From: Jamie Brown [REDACTED]
Sent: 20 July 2018 15:43
To: Planning.Responses
Subject: BR-126-18

TO:	Arun District Council FAO: Simon Davis
FROM:	Highways, WSCC
DATE:	20/07/2018
LOCATION:	28, Canada Grove, Bognor Regis, West Sussex, PO21 1DN
SUBJECT:	BR/126/18/DOC Application for approval of details reserved by condition imposed under planning permission BR/282/13 relating to condition No. 3 (Cycle storage), 4 (Storage of waste and recycling).
DATE OF SITE VISIT:	N/A
RECOMMENDATION:	
S106 CONTRIBUTION TOTAL:	N/A

SECURE BIN & CYCLE STORAGE PLAN Dr 2b

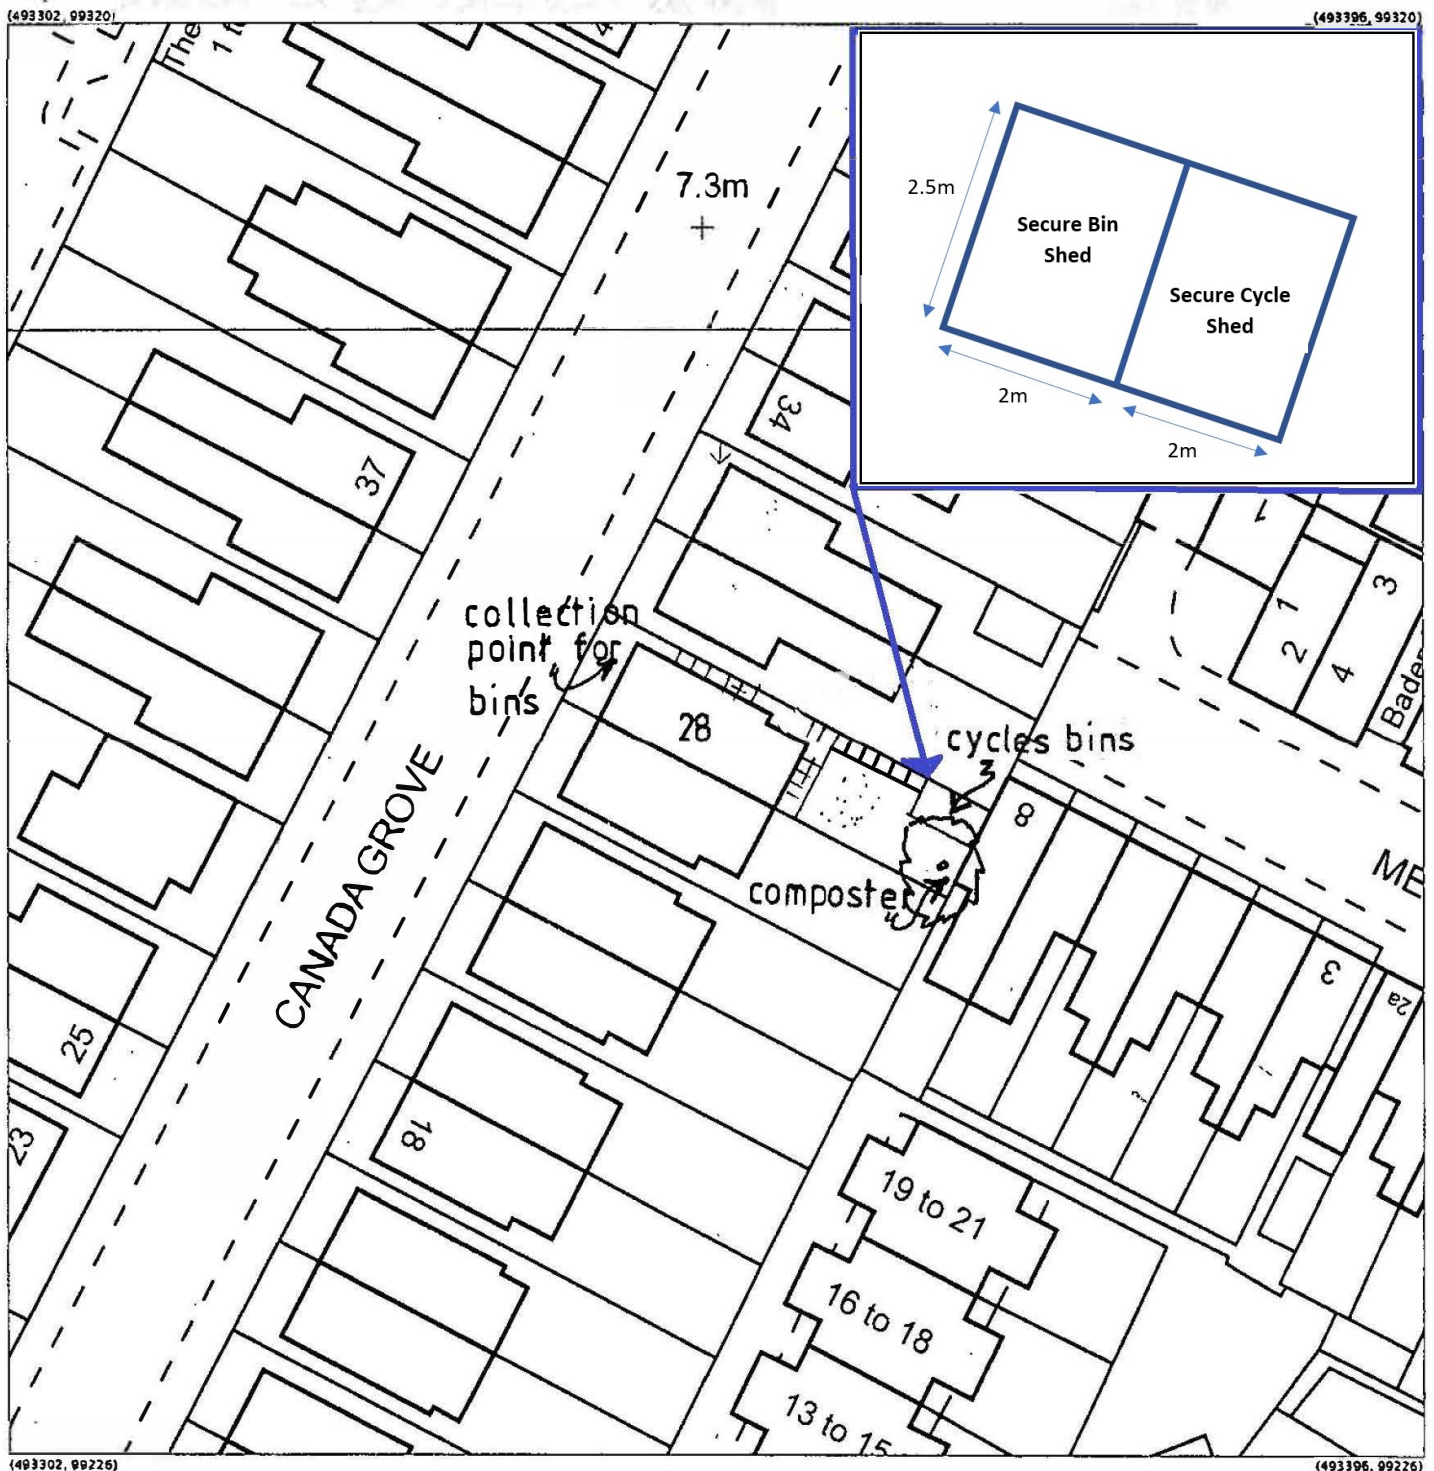
For the purposes of this application the Condition most relevant to highway matters is Condition 3 for Cycle Parking. The LHA have reviewed drawings provided and although primitive in detail they do include secure and covered cycle parking is provided to the rear of the site. On that basis the LHA are satisfied with the proposed discharge of Condition 4.
